**A66 Northern Trans-Pennine Project
TR010062**

**Development Consent Order Application
6.1 Errata Report**

September 2022

6.1 DEVELOPMENT CONSENT ORDER ERRATA

Drawing Title
**Special Category Land Plans
Regulation 5(2)(i)
Sheet 1 of 2**

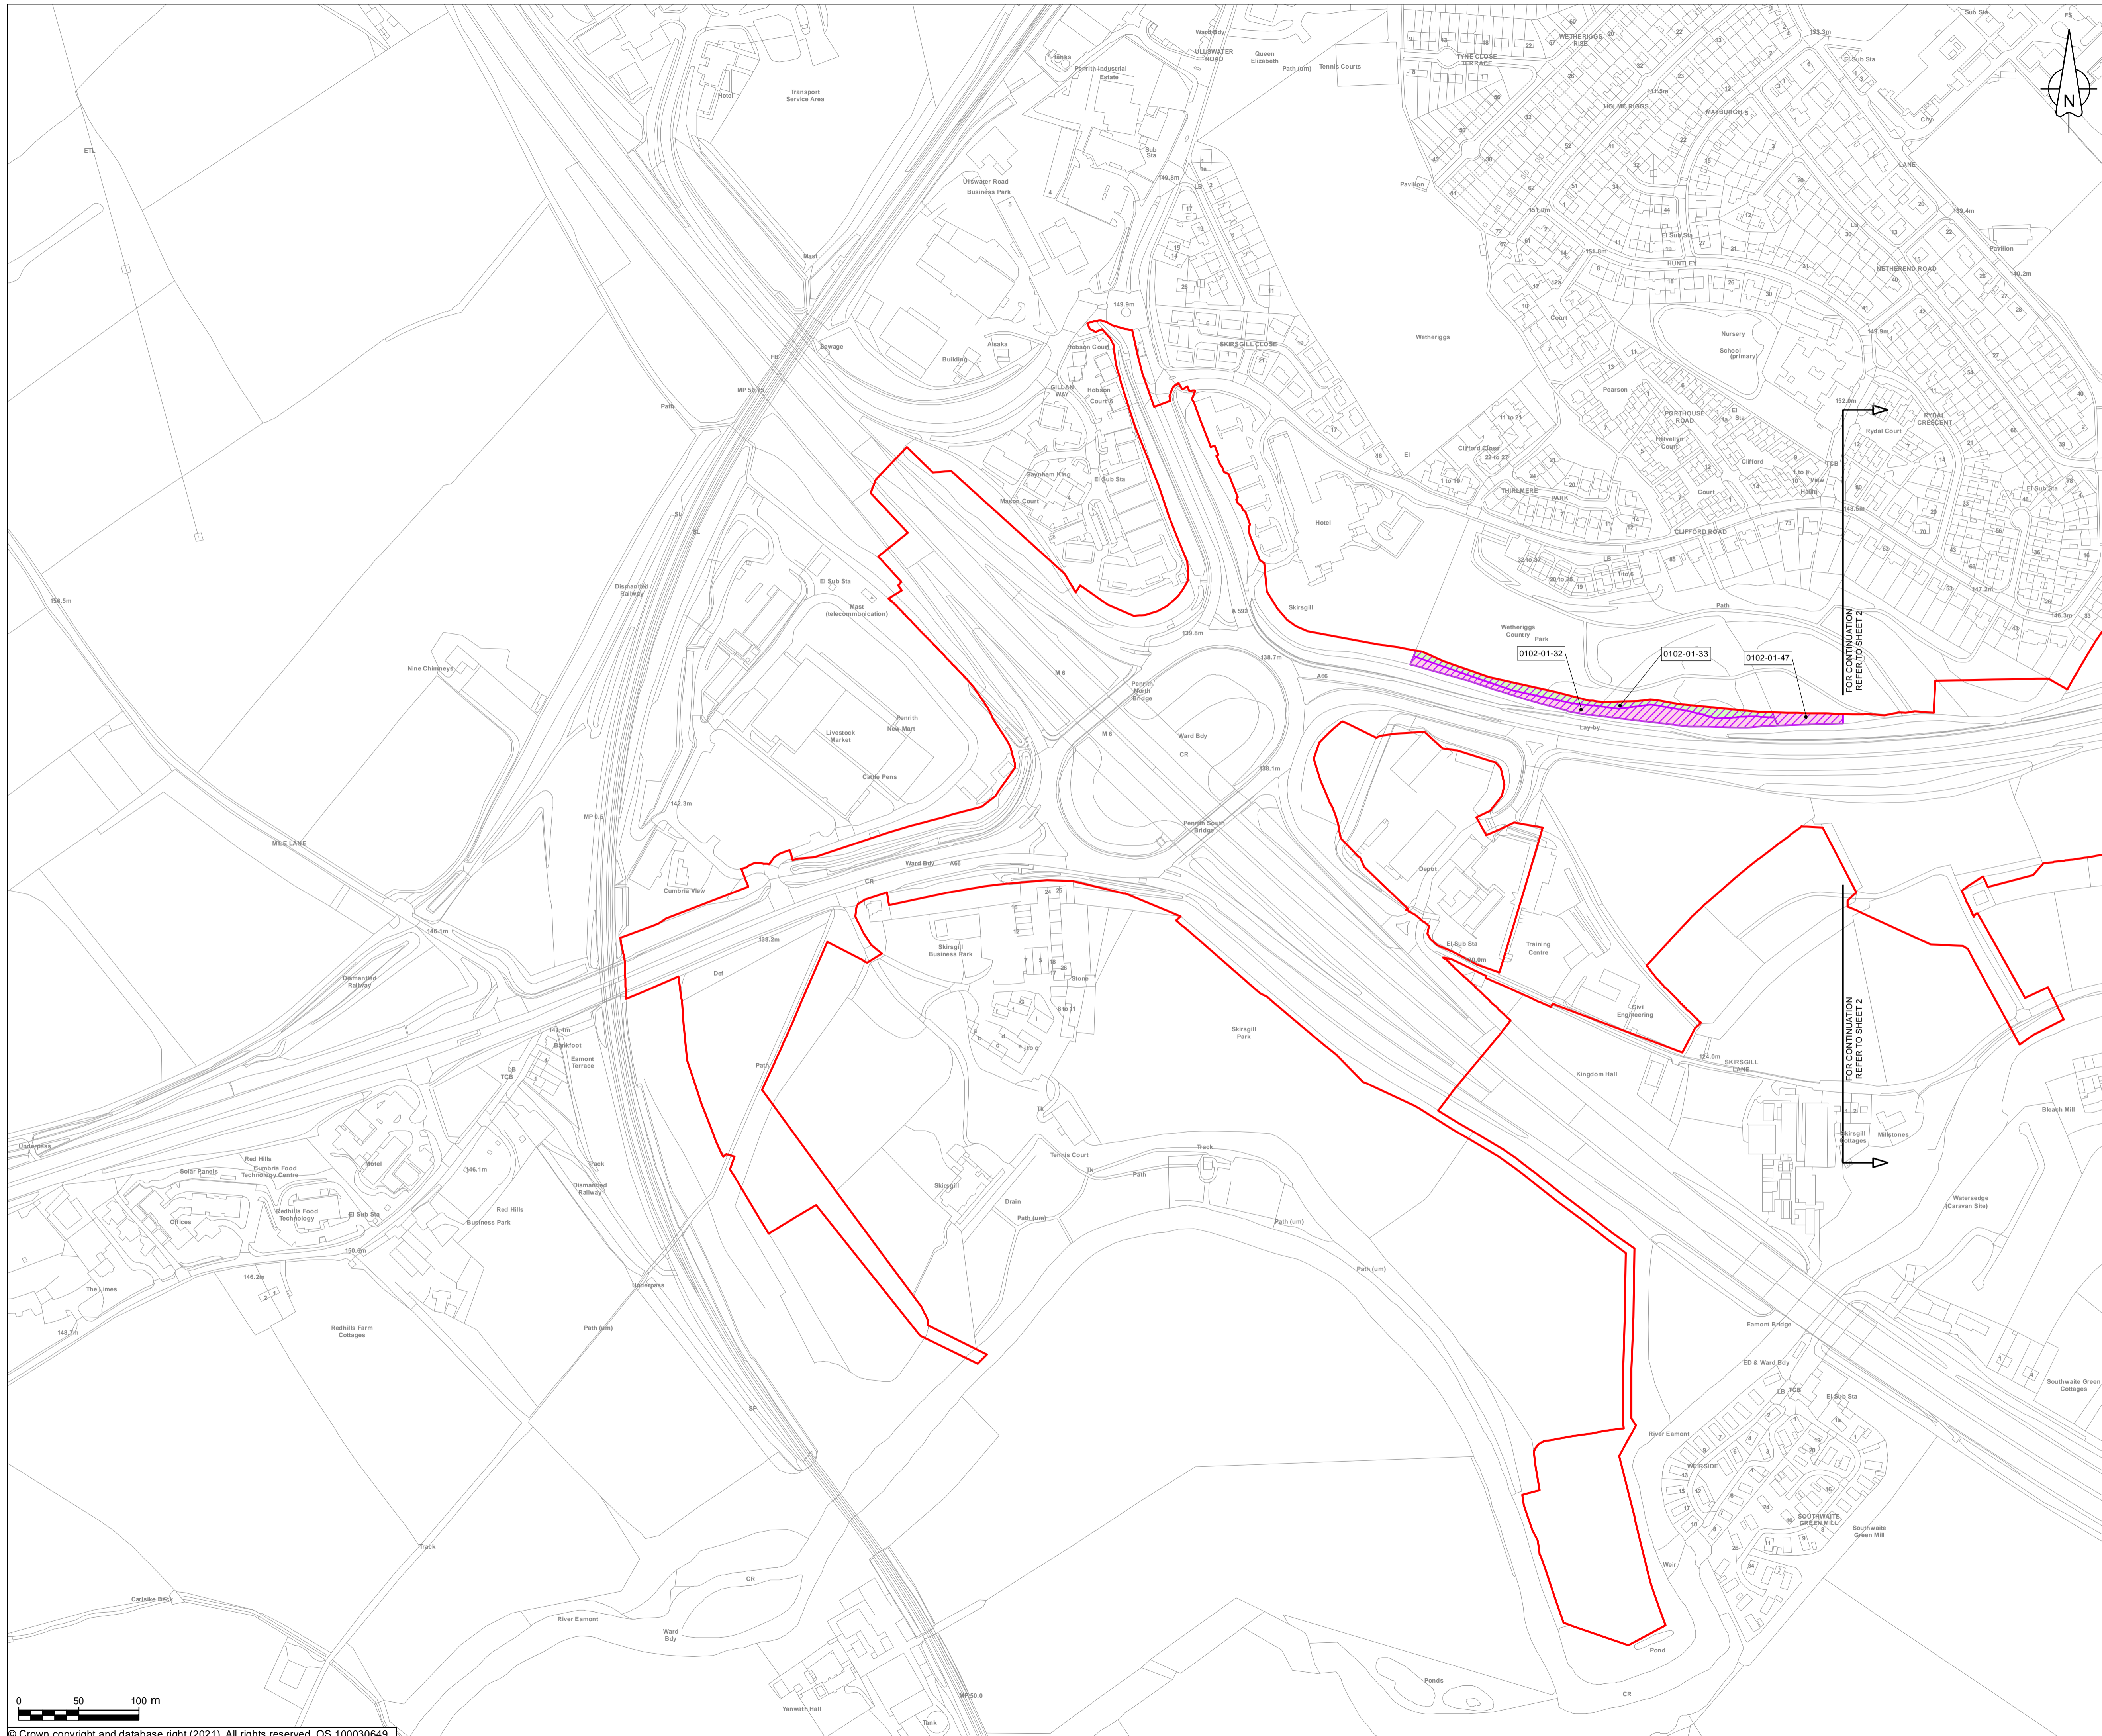
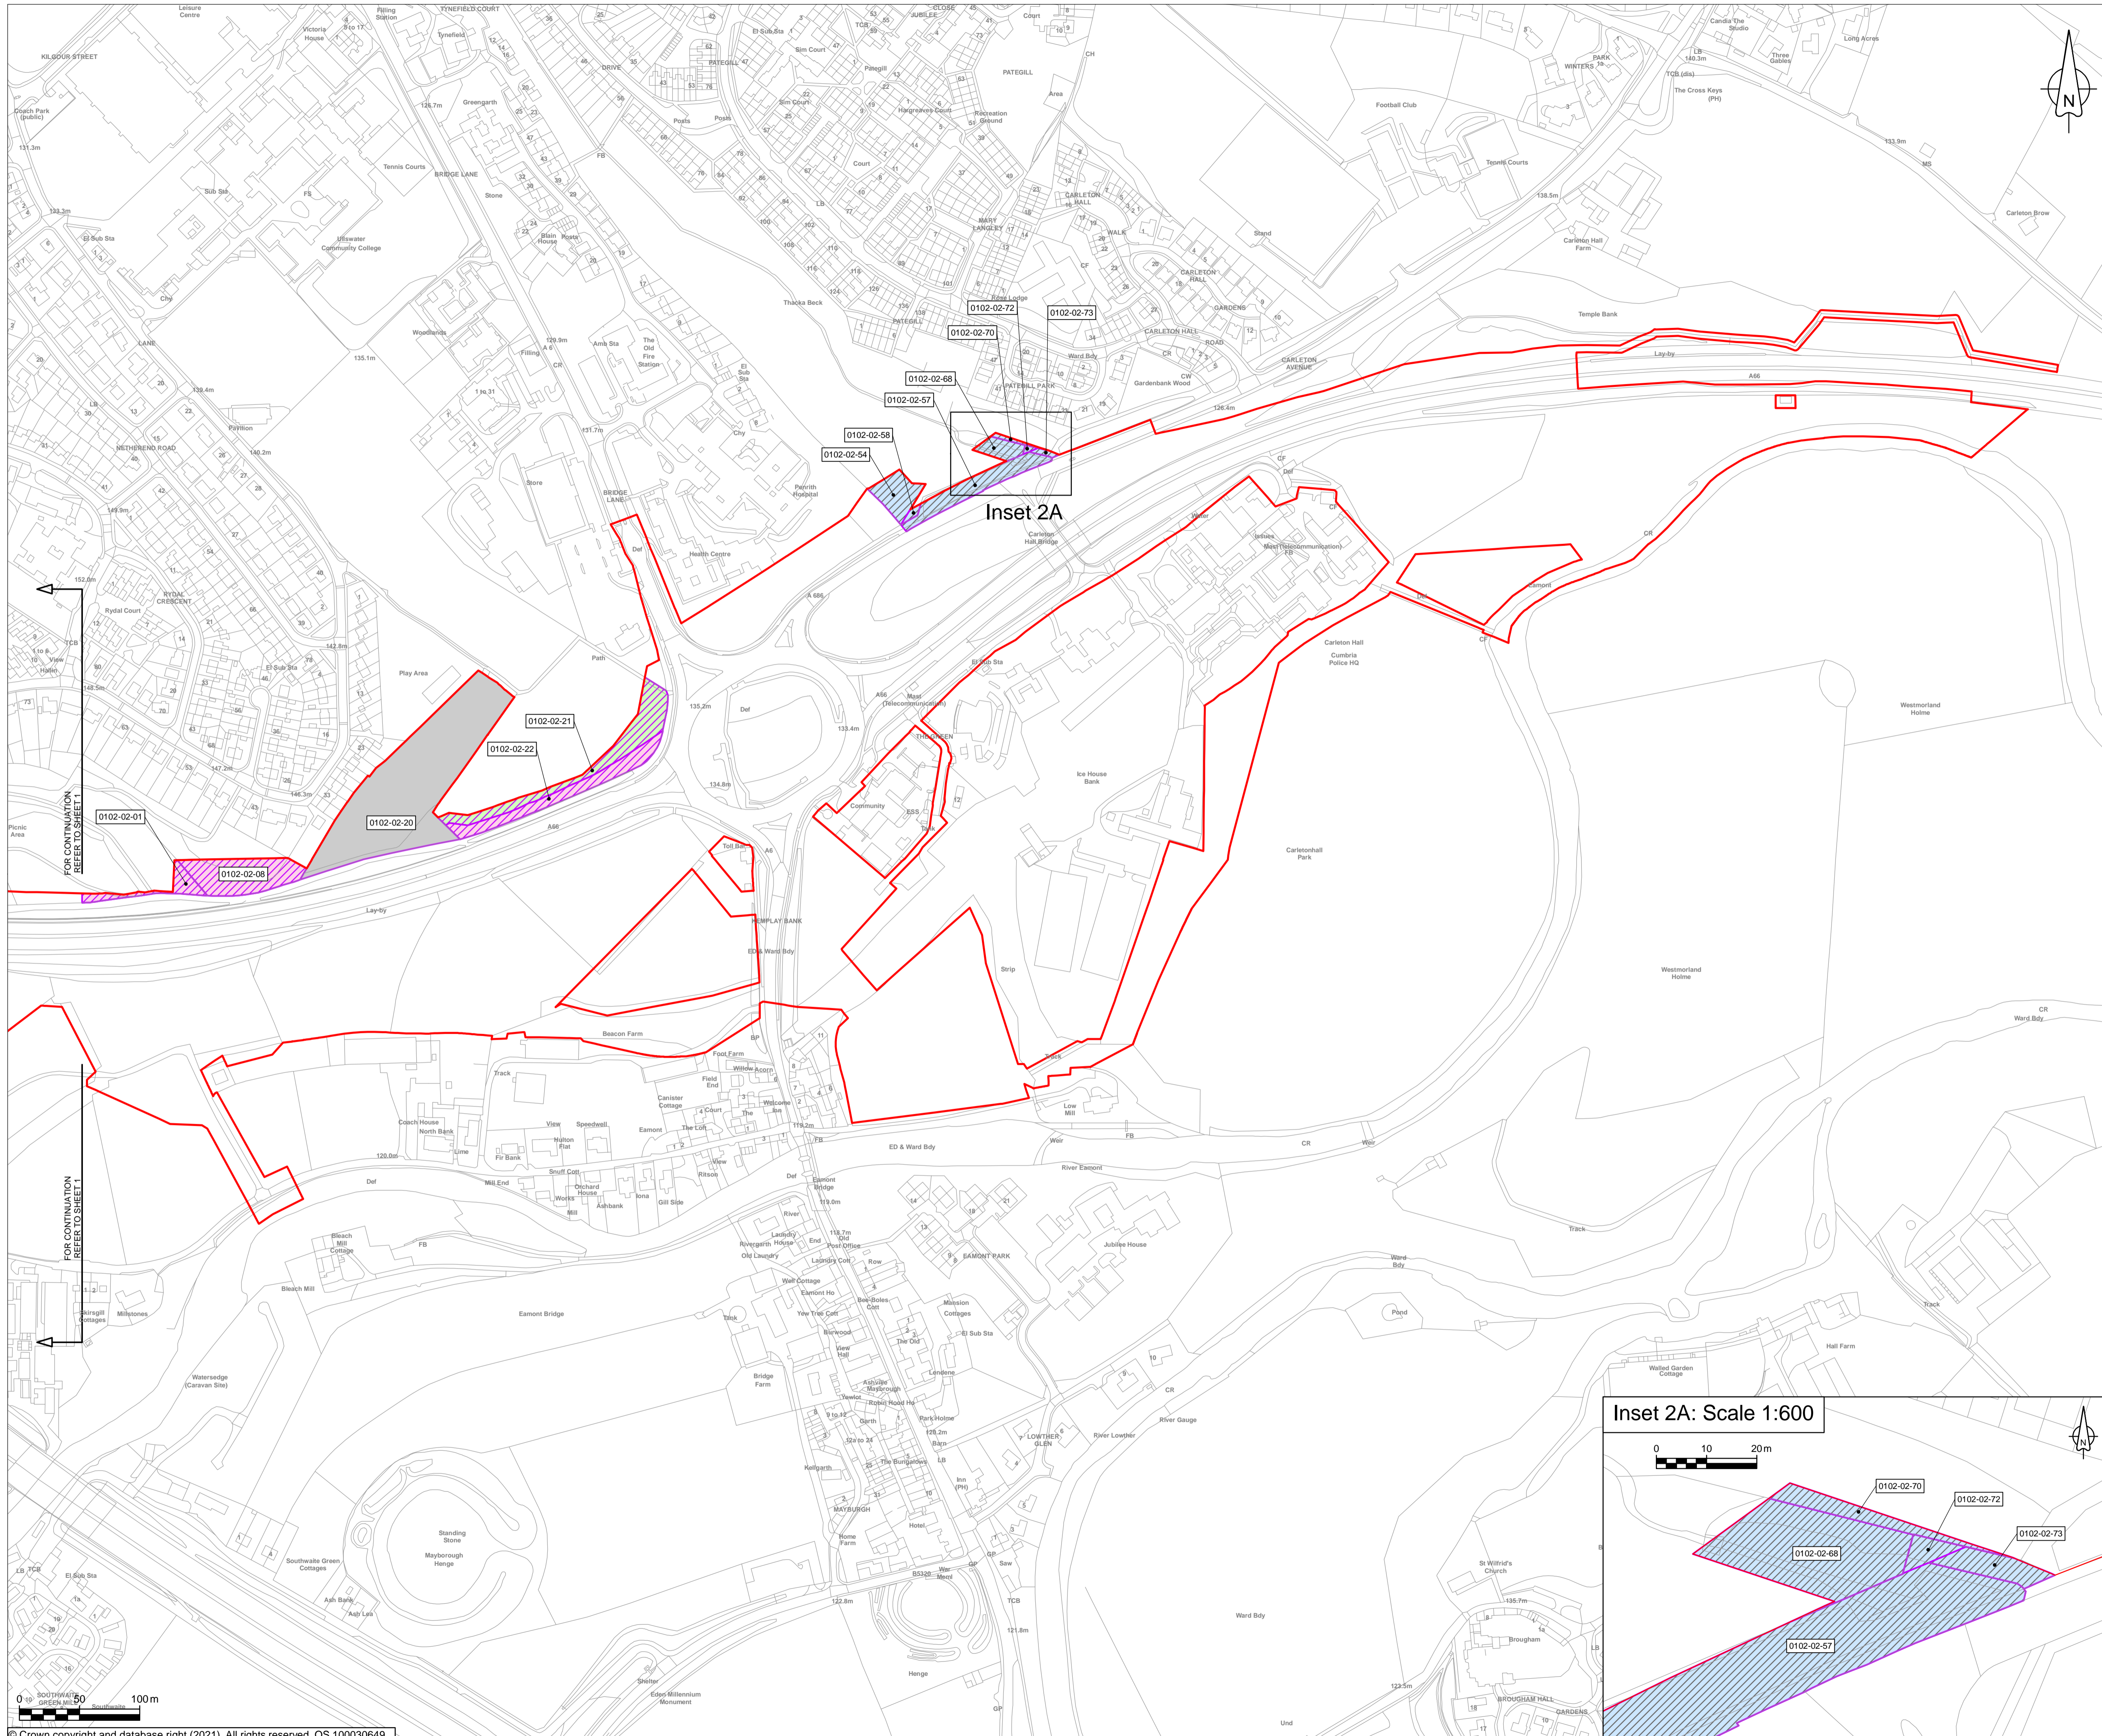
APP-299 5.8 Statement of Reasons	Paragraph 2.1.9	Amendment to provide clarity regarding M6 Junction 40 and Kemplay Bank Roundabout.	The M6 Junction 40 to Kemplay Bank scheme would provide a three-lane circulatory carriageway with spiral markings, within the footprint of the current roundabout at M6 Junction 40. The A66 eastern arm of the roundabout would be widened to three lanes in each direction between M6 Junction 40 and Kemplay Bank Roundabout to increase capacity for local movements around Penrith. Widening would be required on the following five approach arms to M6 Junction 40 to provide additional lanes and a dedicated left turn facility, each controlled under its own signal phase : M6 North, M6 South, A66 East, A66 West, and A592 Ullswater Road.																														
APP-299 5.8 Statement of Reasons	Paragraph 2.1.17	Clarification on the police observation points	A police observation point would be included on The verges on the Kemplay Bank overbridges are an appropriate width for use as a police observation point for intermittent mobile speed enforcement purposes.																														
APP-299 5.8 Statement of Reasons	Paragraph 2.1.69	Incorrect number of ponds referenced.	18-20 ponds are proposed at low points in the scheme to attenuate drainage and run-off from the road in order to manage the water quality before it is discharged into the surrounding watercourses. Shared and dedicated access tracks are proposed to be provided to the north and to the south of the road to facilitate access to ponds for maintenance purposes and to accommodate landowner movements.																														
APP-299 5.8 Statement of Reasons	Paragraph 7.2.10 – associated table	Plot 0102-02-54 was not included within the table.

<table><tr> <th data-bbox="1025 772 1205 884">Land use powers sought in the DCO</th> <th data-bbox="1205 772 1361 884">Plots</th> <th data-bbox="1361 772 1458 884">Area (sqm)</th> <th data-bbox="1458 772 1637 884">Replacement land to be provided</th> <th data-bbox="1637 772 1765 884">Plots</th> <th data-bbox="1765 772 1890 884">Area (sqm)</th> </tr><tr> <td data-bbox="1025 916 1205 1082">Land to be acquired compulsorily</td> <td data-bbox="1205 916 1361 1082">0102-01-32 0102-01-47 0102-02-01 0102-02-08 0102-02-22</td> <td data-bbox="1361 916 1458 1082">8,020</td> <td data-bbox="1458 916 1637 1082">Yes</td> <td data-bbox="1637 916 1765 1082">0102-02-20</td> <td data-bbox="1765 916 1890 1082">10,833</td> </tr><tr> <td data-bbox="1025 1082 1205 1337">Land to be subject to the creation and acquisition of new rights (permanent rights for environmental mitigation)</td> <td data-bbox="1205 1082 1361 1337">0102-02-54 0102-02-57 0102-02-58 0102-02-68 0102-02-70 0102-02-72 0102-02-73</td> <td data-bbox="1361 1082 1458 1337">3,595 4,624</td> <td data-bbox="1458 1082 1637 1337">No, because the land, when burdened with the new rights will be no less advantageous than before</td> <td data-bbox="1637 1082 1765 1337">N/A</td> <td data-bbox="1765 1082 1890 1337">N/A</td> </tr></table>

temporary possession			compulsory acquisition)			
			Total area of special category land on S0102: 16,790 16,819 sqm						
APP-299 5.8 Statement of Reasons	Section 2.2	Paragraph numbering error in Section 2.2 Case for the Project	The paragraph numbers should be 2.2.1 to 2.2.13 and not 1.1.1 to 1.1.13.						
APP-344 5.19 Rights of Way and Access Plans	Scheme 0405 Temple Sowerby to Appleby; Sheet 3:	Typographical error	Existing Winthorn to be demolished.
